CITY OF ALBUQUERQUE

December 13, 2022

Re: La Luz Hub TI
1115 Griegos Rd. NW
Traffic Circulation Layout
Architect's Stamp XX-XX-XX (F14-D082)

TCL-1

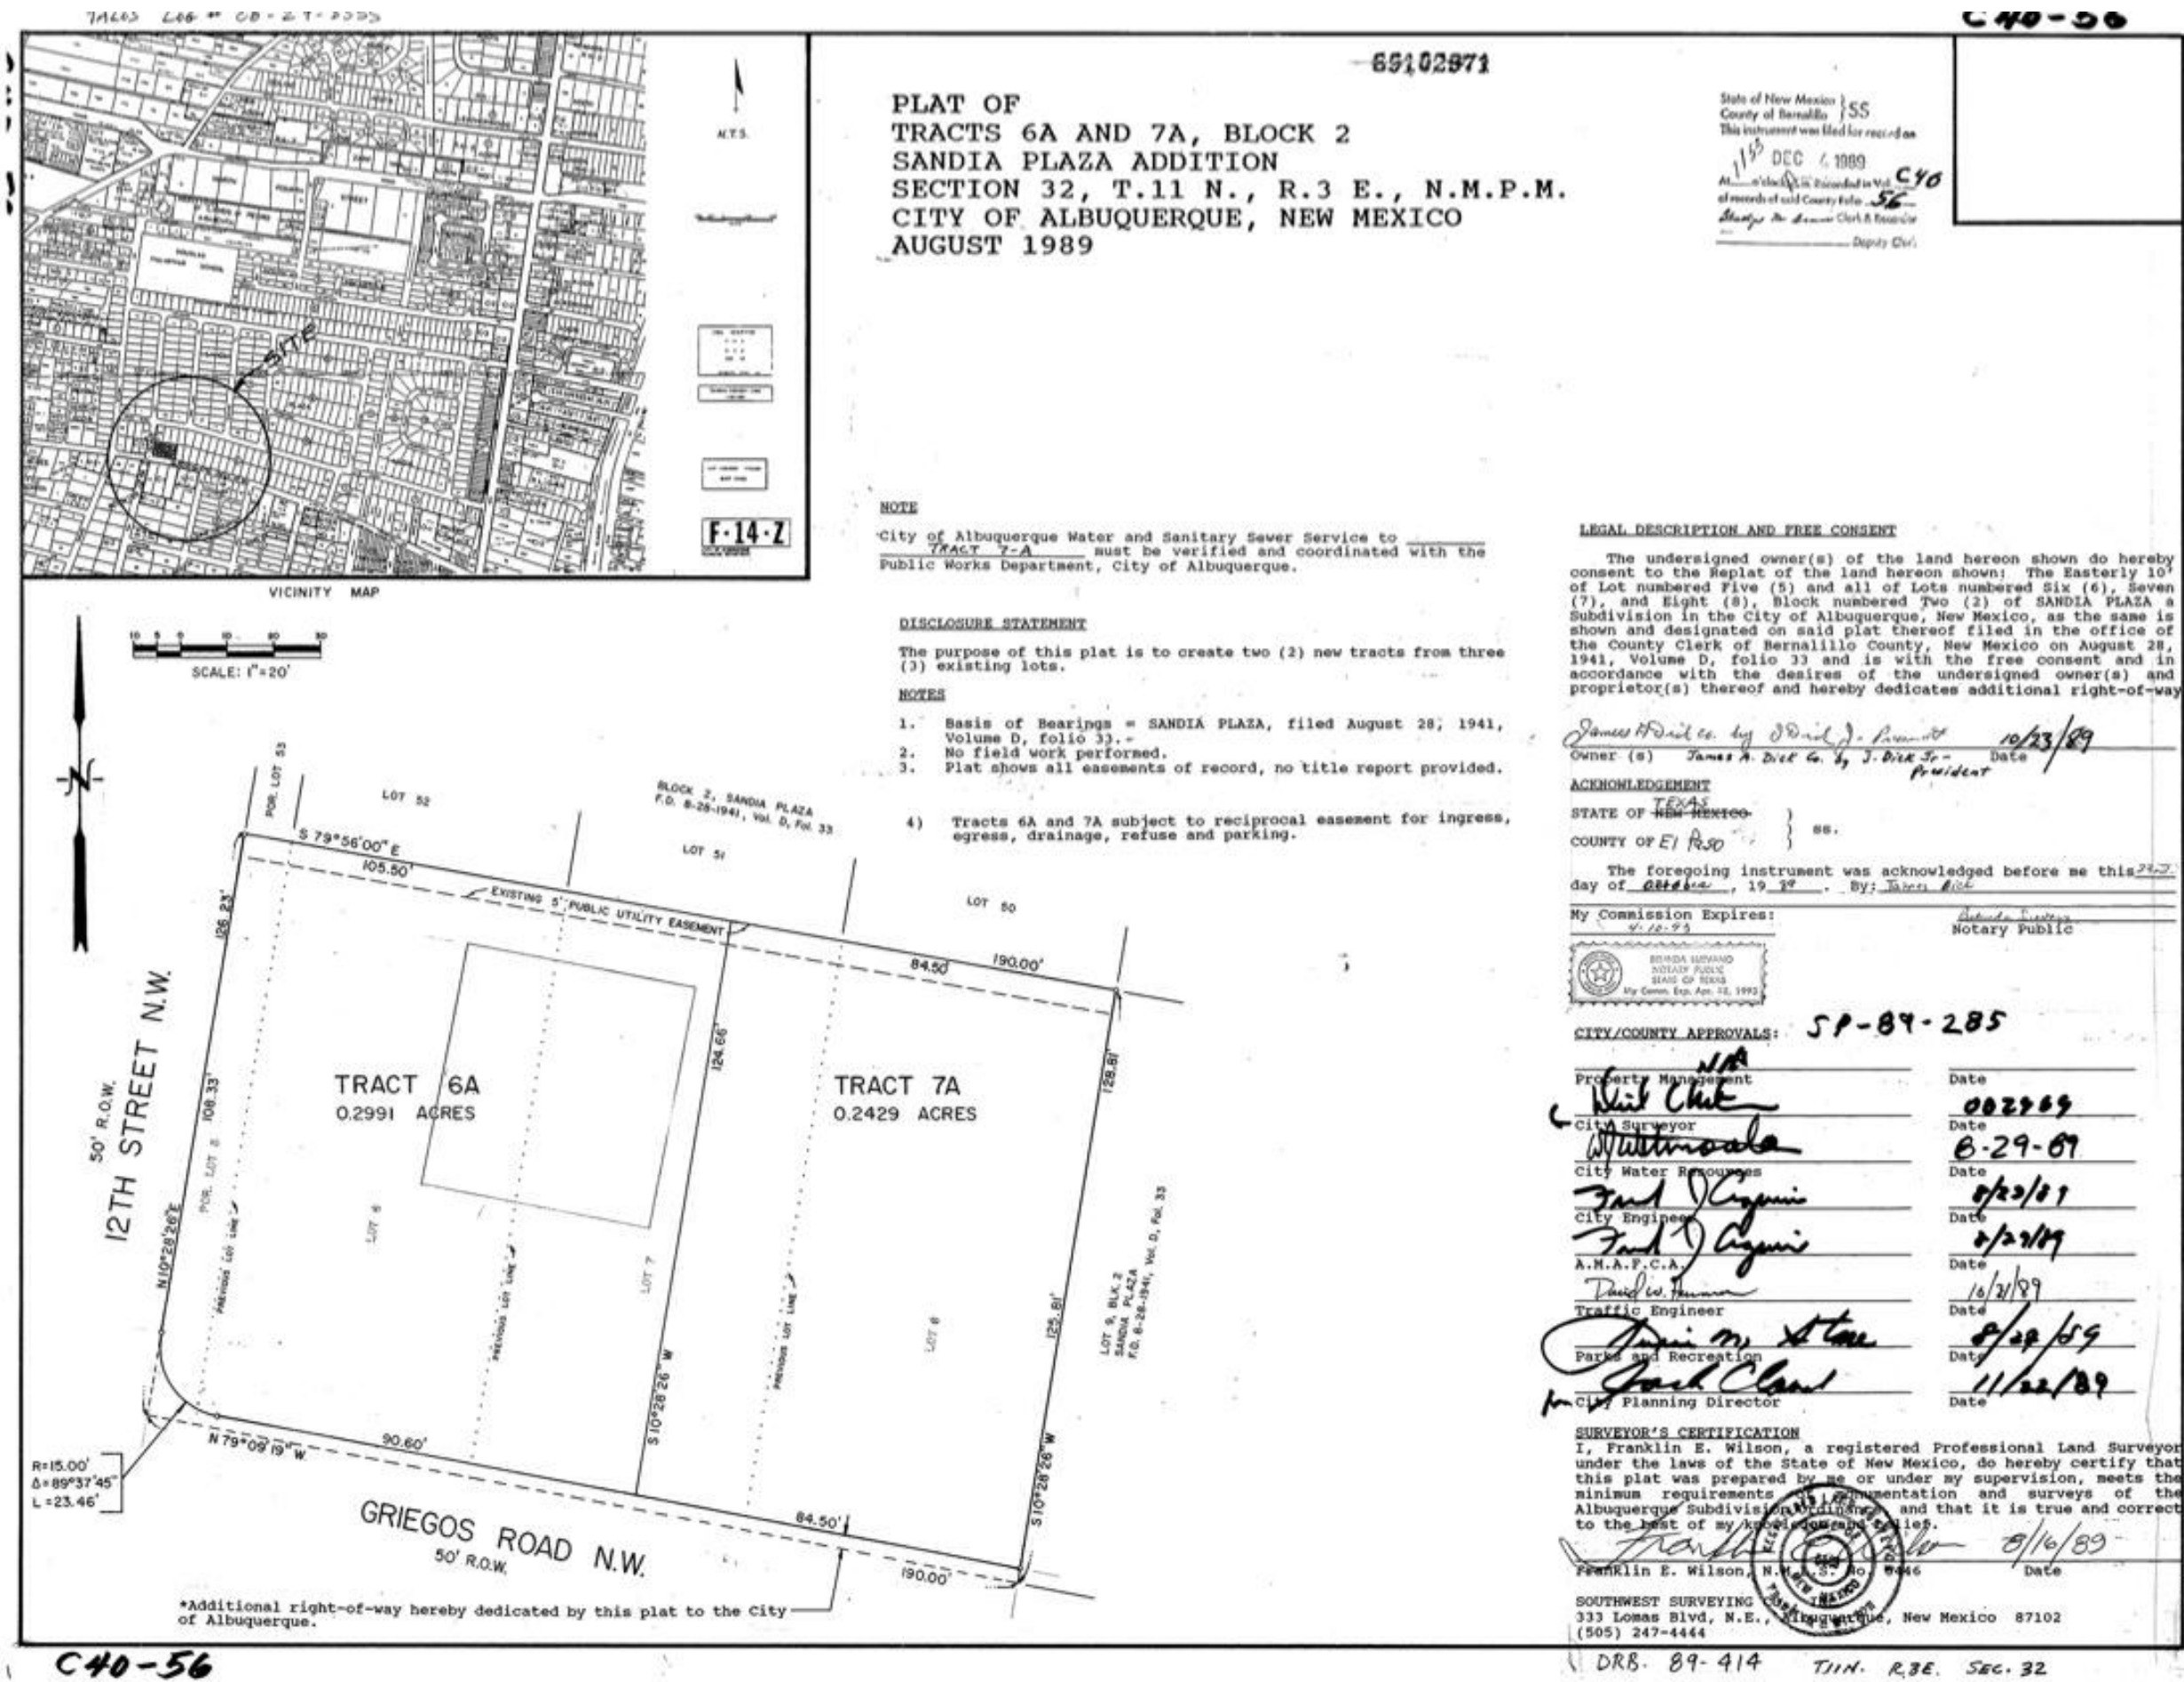
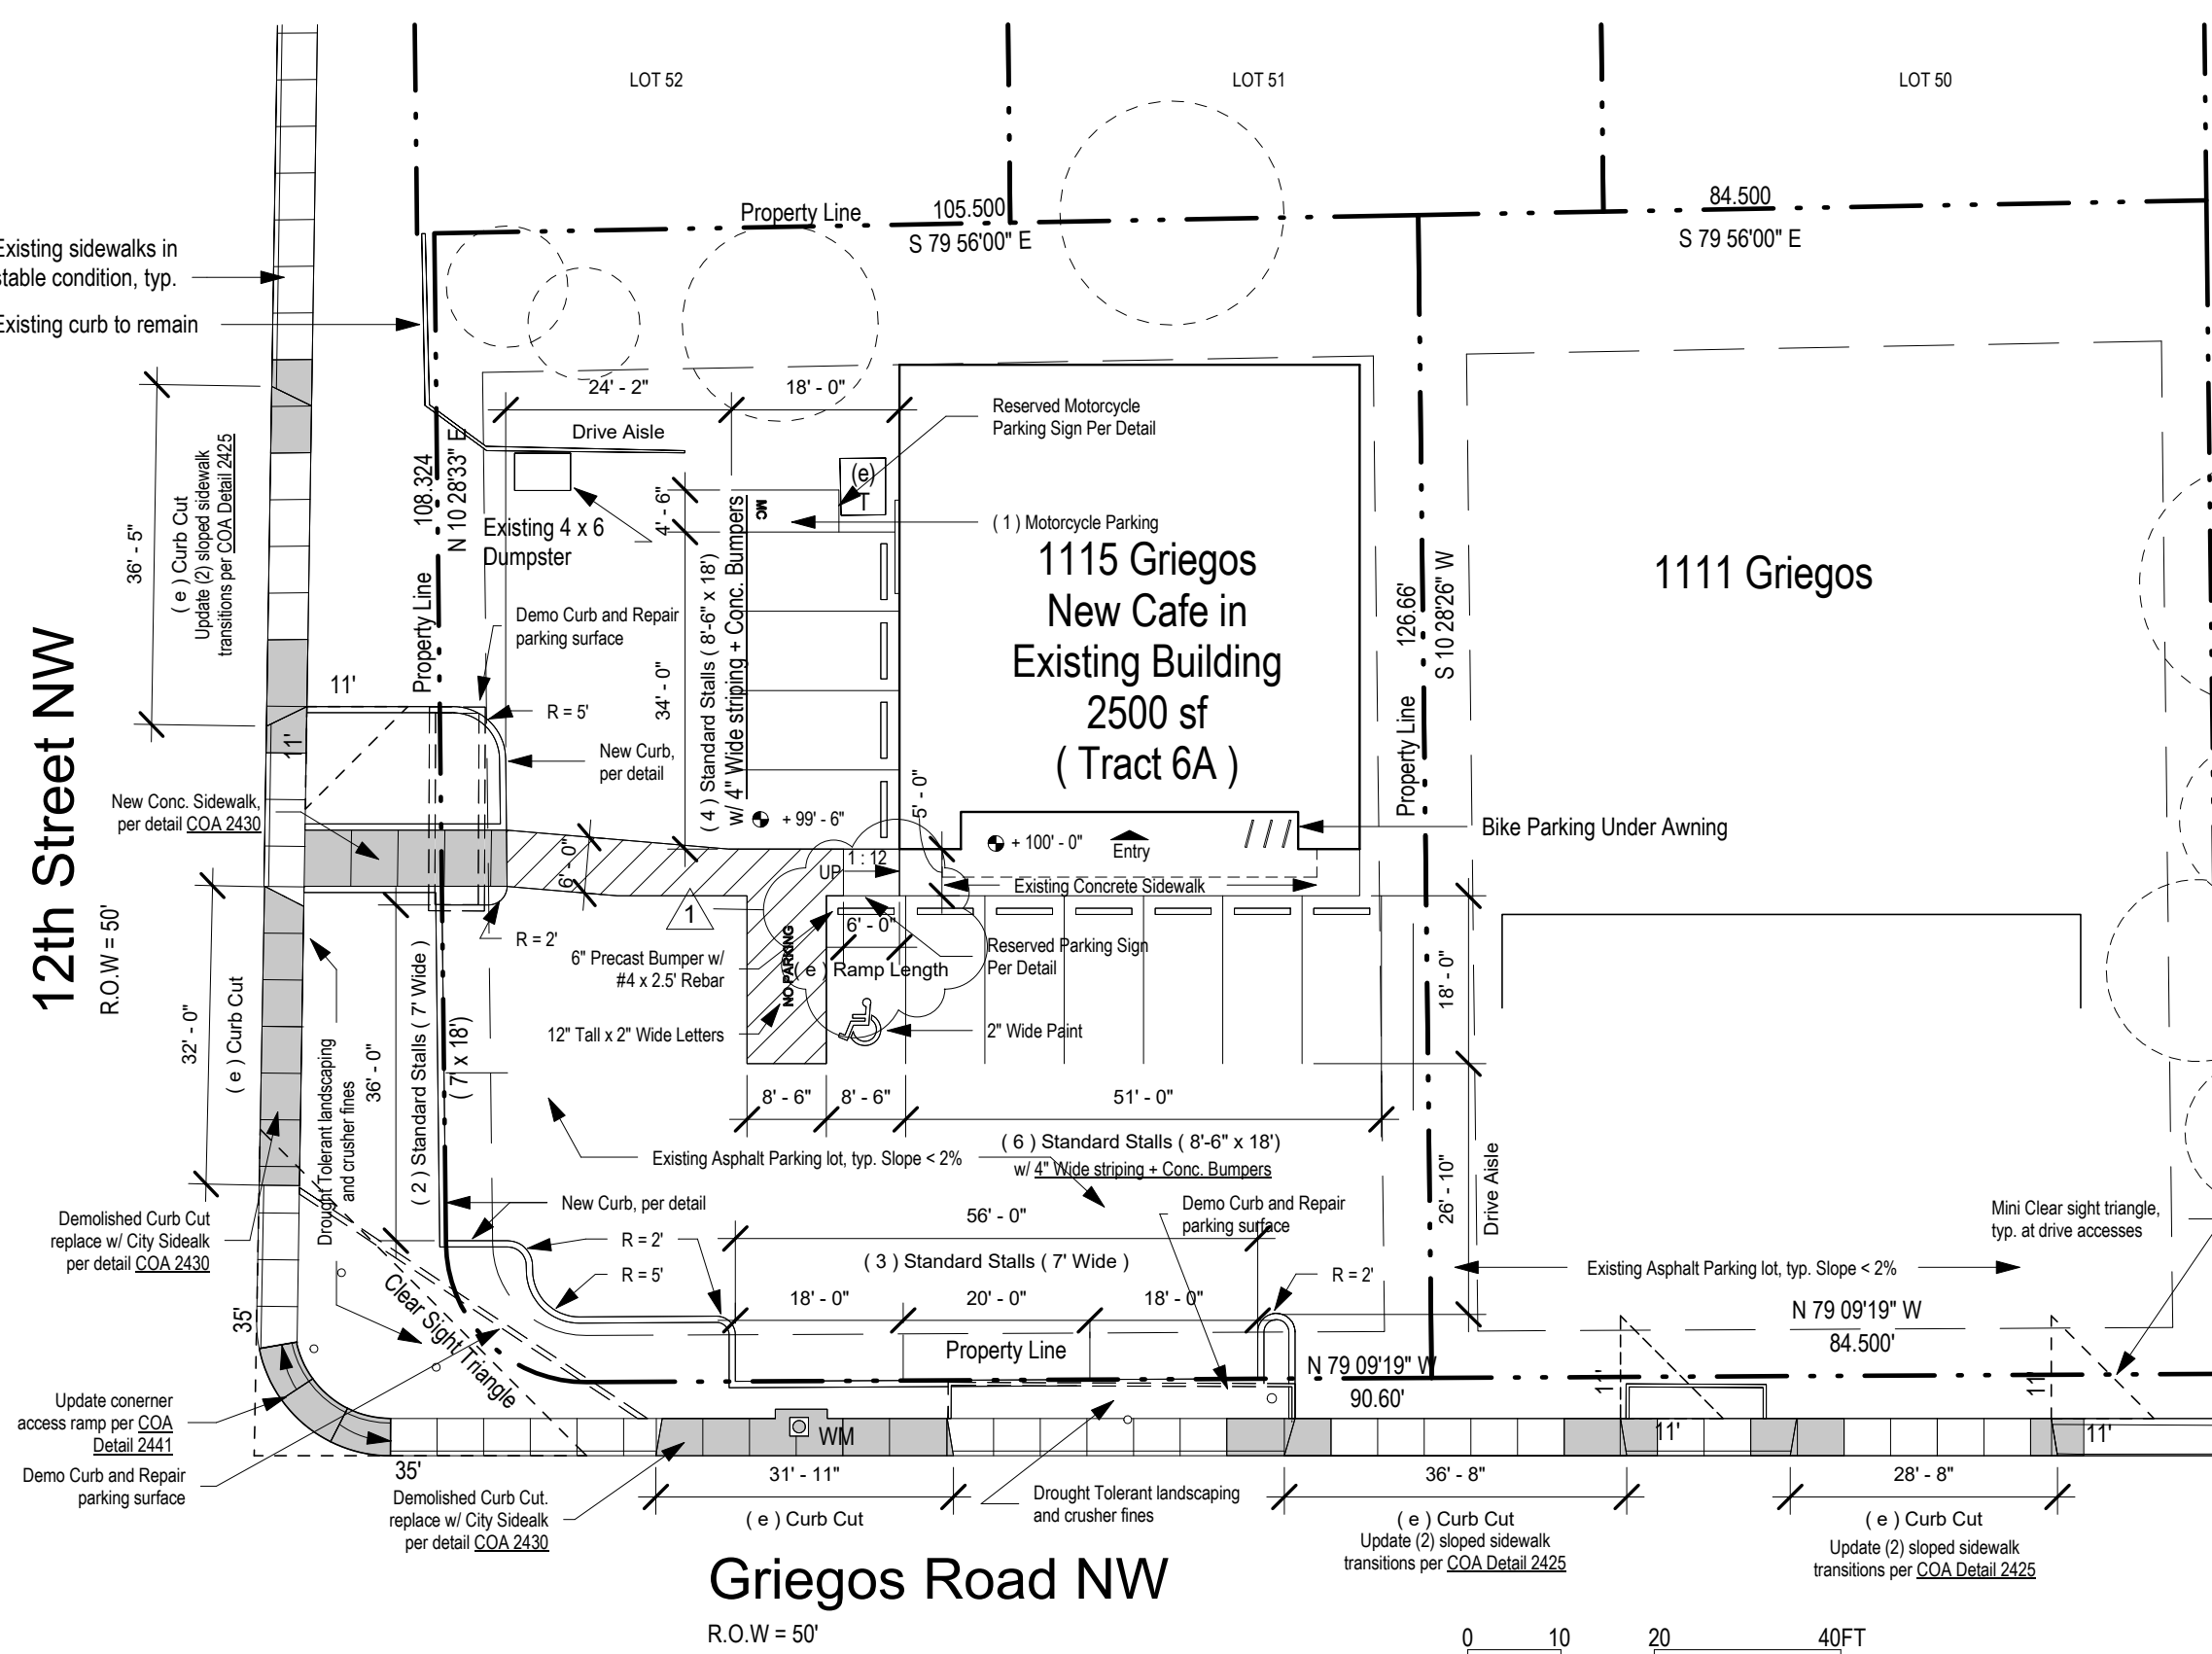
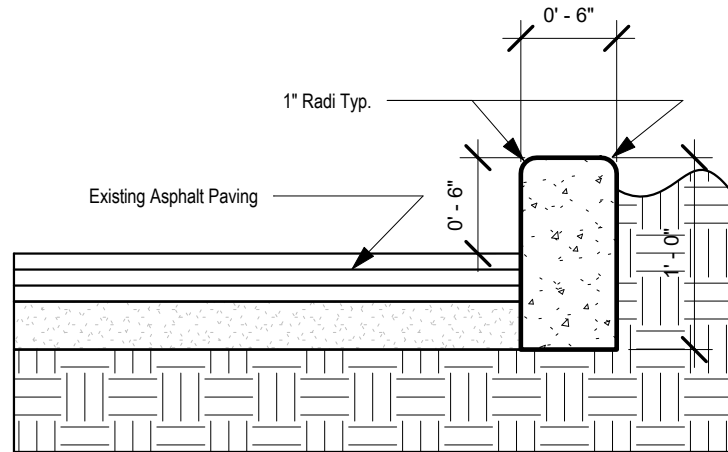
1. The traffic circulation layout must be dated by an architect licensed in the state of New Mexico.
2. Please update the existing driveway accesses to the current ADA standard.

3. ADA curb ramp at the corner of Griegos Rd. and 12th St. must be updated to current standards and have truncated domes installed.
4. Please show the location of the food truck and the proposed outdoor seating on the site plan.

5. Provide details for the interior ADA ramp.
6. Provide a copy of Fire Marshal and Solid Waste approval.
7. The pavement marking "MC" should be shown in the opposite direction for motorcycles entering the parking space.

8. Please specify the City Standard Drawing Number when applicable.
9. Add a note stating "All broken or cracked sidewalk must be replaced with sidewalk and curb & gutter." A build note must be provided referring to the appropriate City Standard drawing.
